SSD 8963 RESPONSE TO SUBMISSIONS TABLE ~ LISMORE BASE HOSPITAL REDEVELOPMENT STAGE 3C NORTH TOWER EXTENSION (NTX)

Table 1

1 Building Elevation - North NTX SSDA
1 : 200

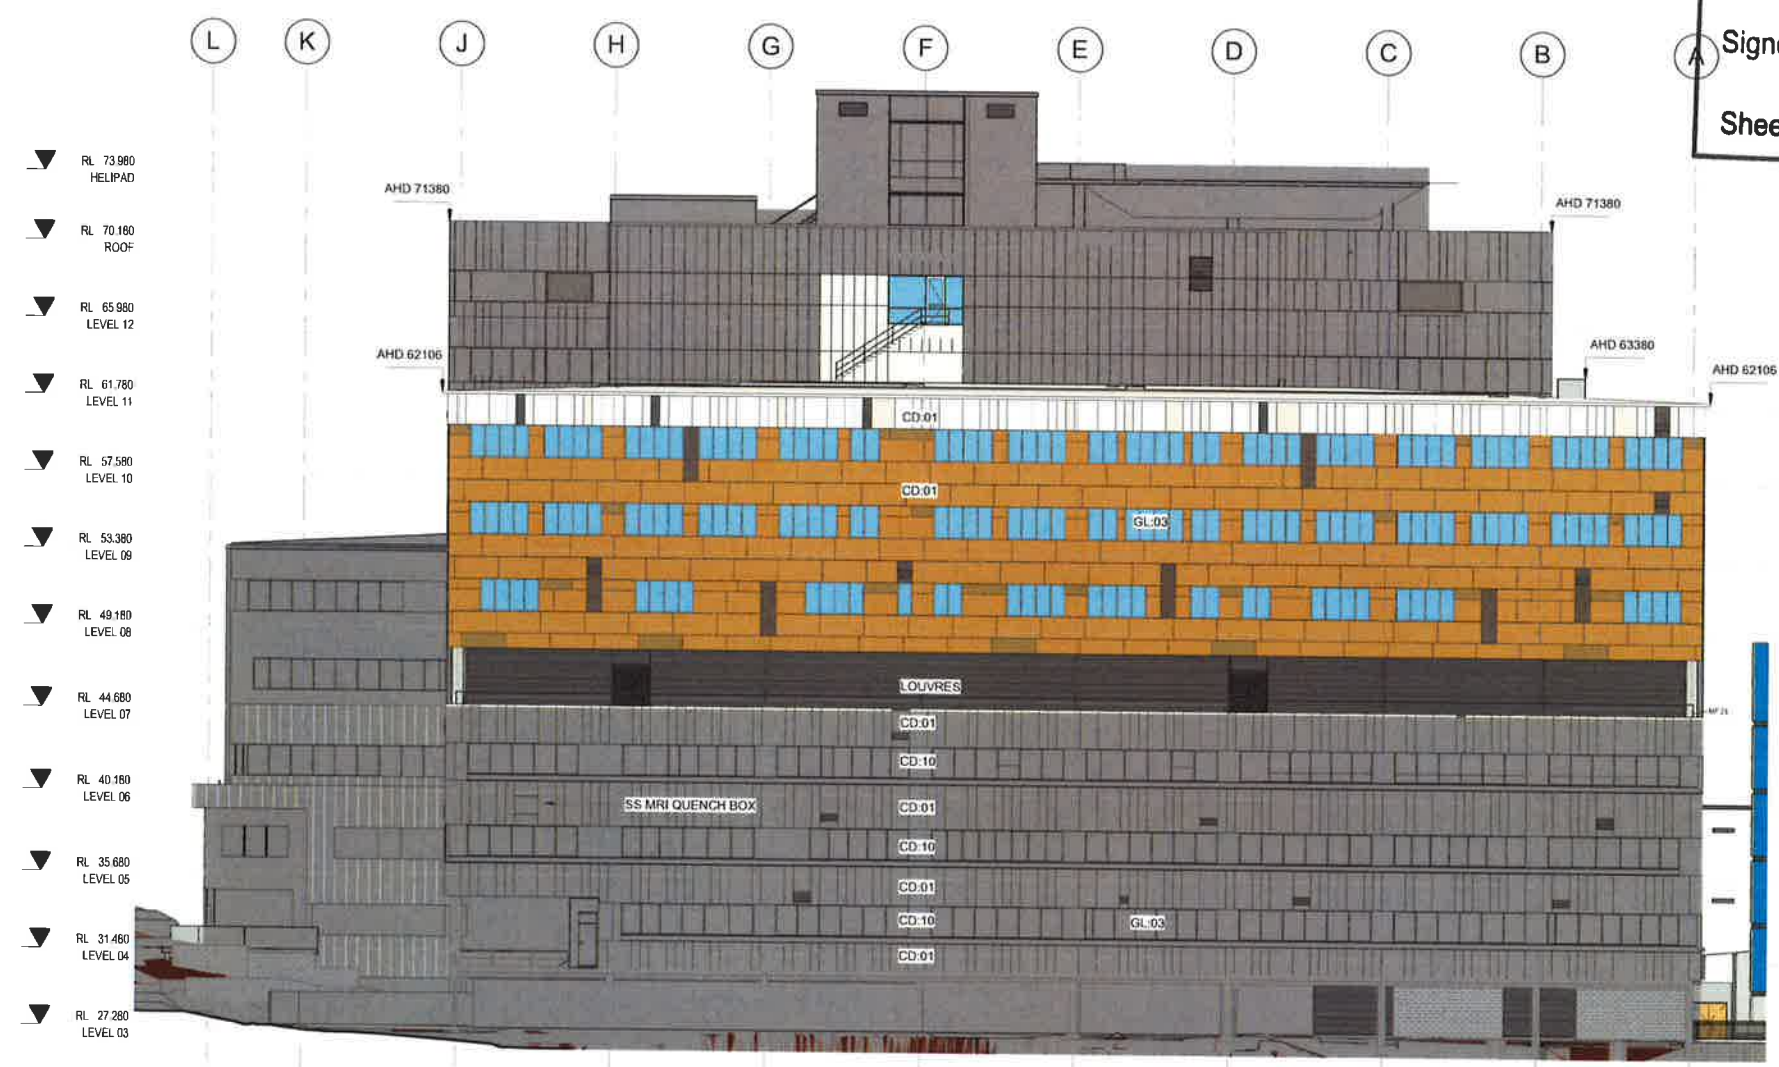
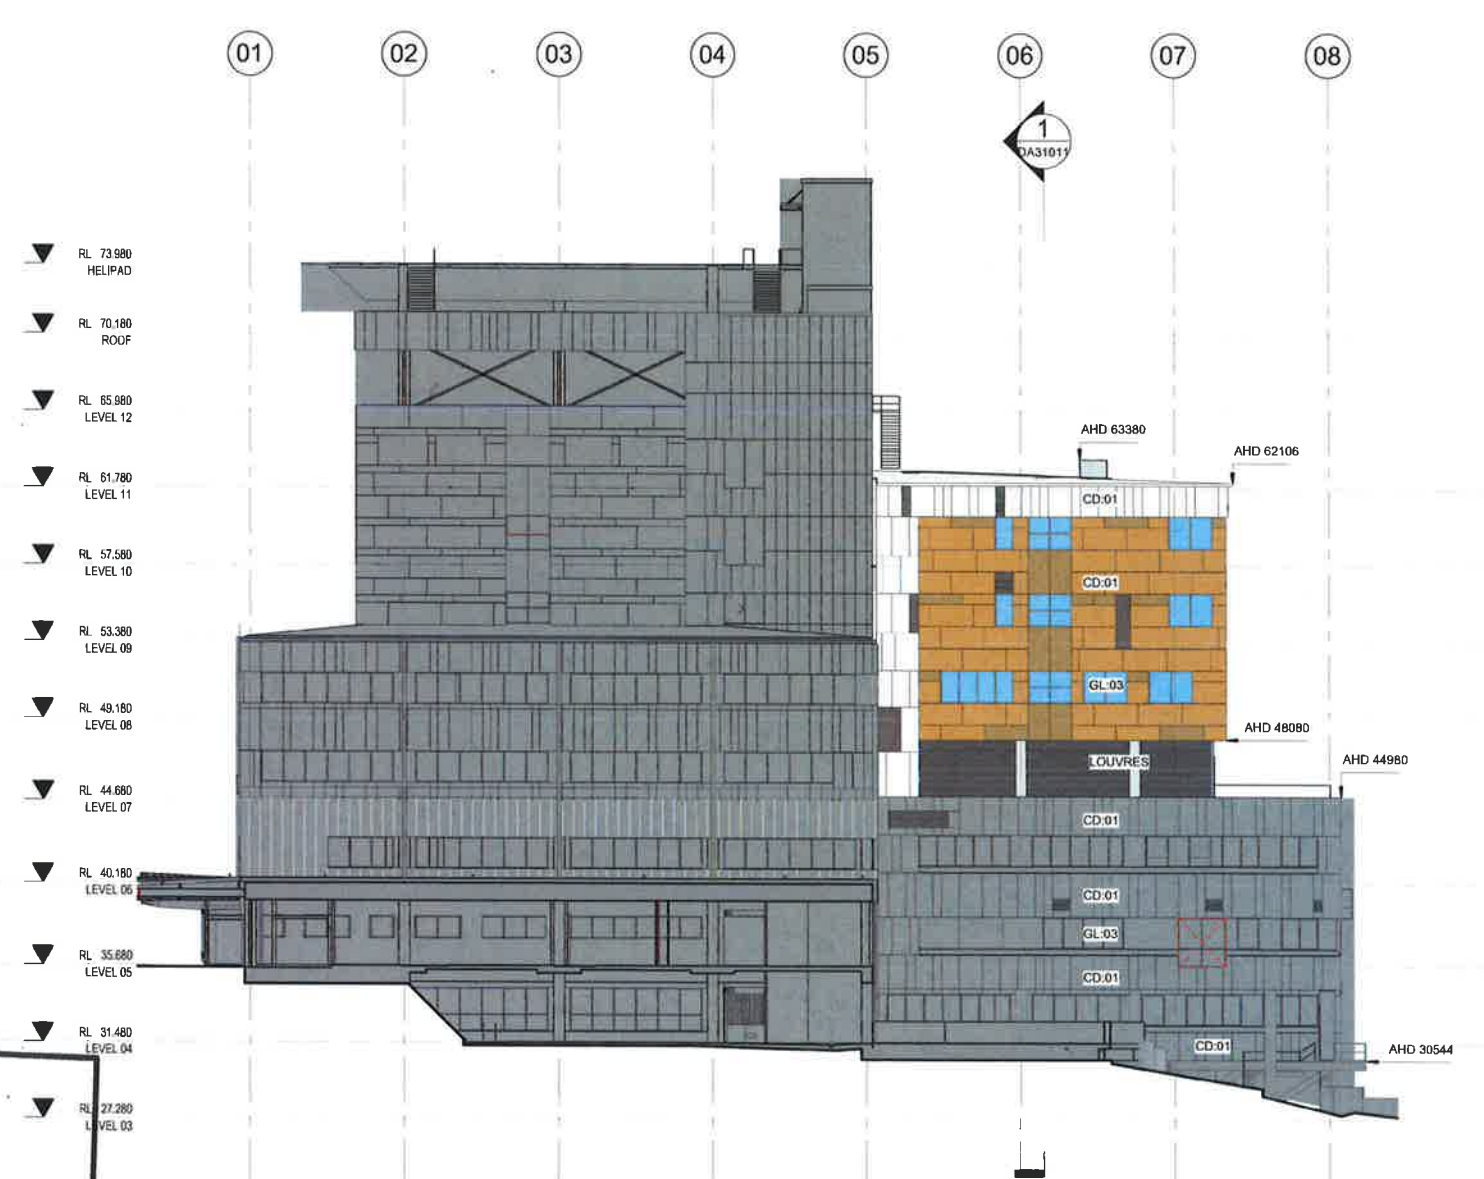
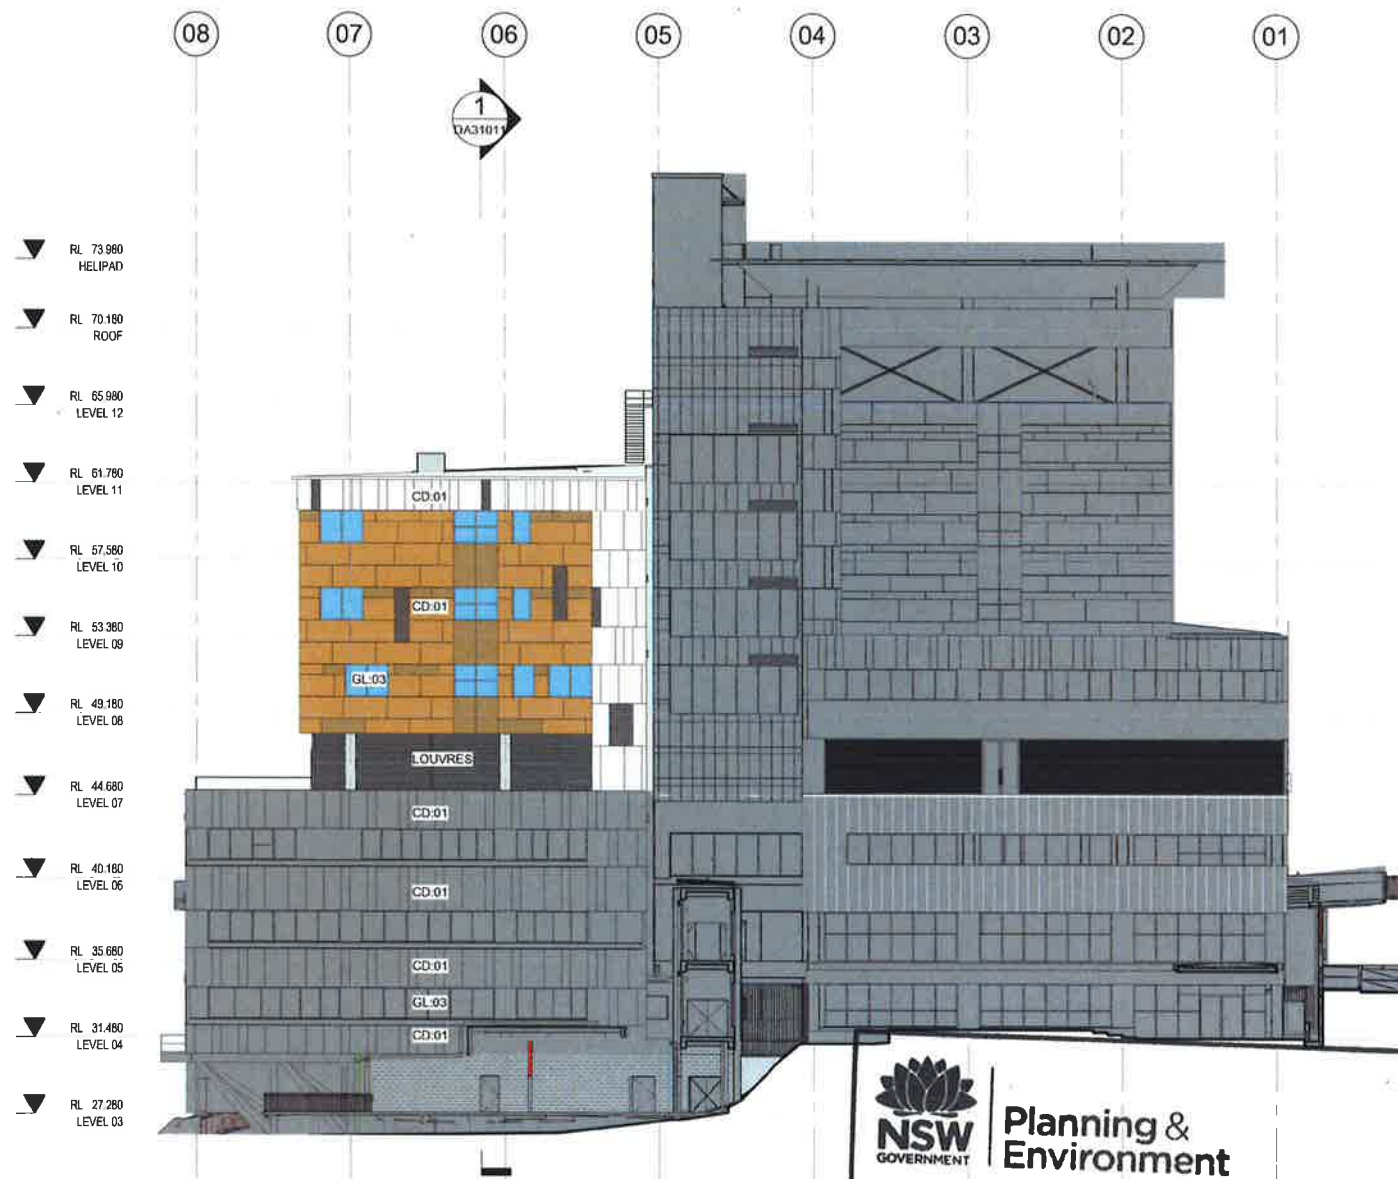
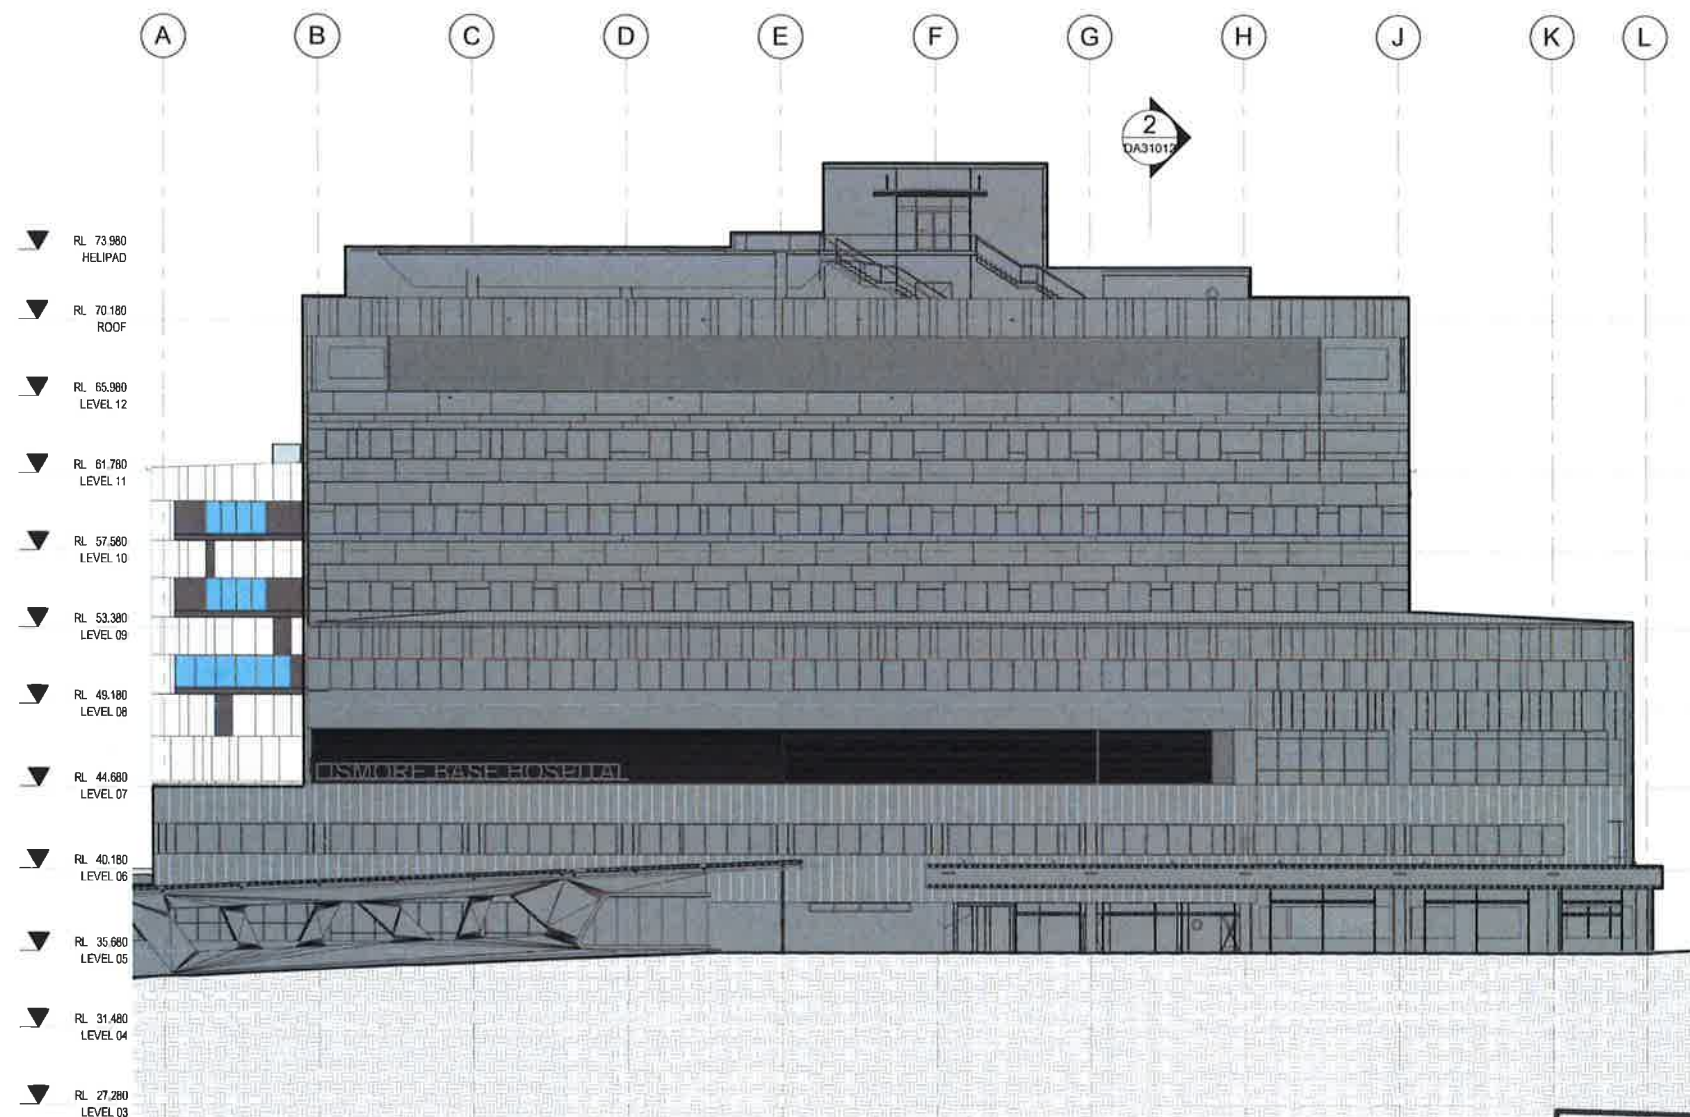
Government Architect (GANSW)	NSW	GANSW is supportive of the height, density, bulk, scale and materiality of the proposed NTX. However, the GANSW notes that the absence of external shading devices is not acceptable and should be justified.	The project Architects, CGA, have provided a response to this matter in Attachment 3. In summary, CGA has advised that the orientation, design and materiality of the building is adequate to minimise the potential for solar heat gain and glare and that therefore, the absence of external shading devices is acceptable and justified on this basis. Refer to Attachment 3 for further details and justification.
		GANSW suggests exploring the following to enhance internal amenity: - Integration of public art, particularly with local community artists; - Lighting optimised for comfort; - Informal gathering spaces; and	CGA has provided a response to the issues of public art and informal gathering spaces in Attachment 3. In summary: - Public art has been incorporated into the Stage 3 development within Level 11 of the south tower (paediatrics ward). Photographs of the existing art installations are included in Attachment 3. - There is additional public art incorporated within the south tower at Levels 4 and 5 (within the link bridge between the south tower and Blocks A, B and C). This is a public display of artwork from Lismore Art Gallery. The NNSW LHD have an agreement with the gallery to rotate the artwork
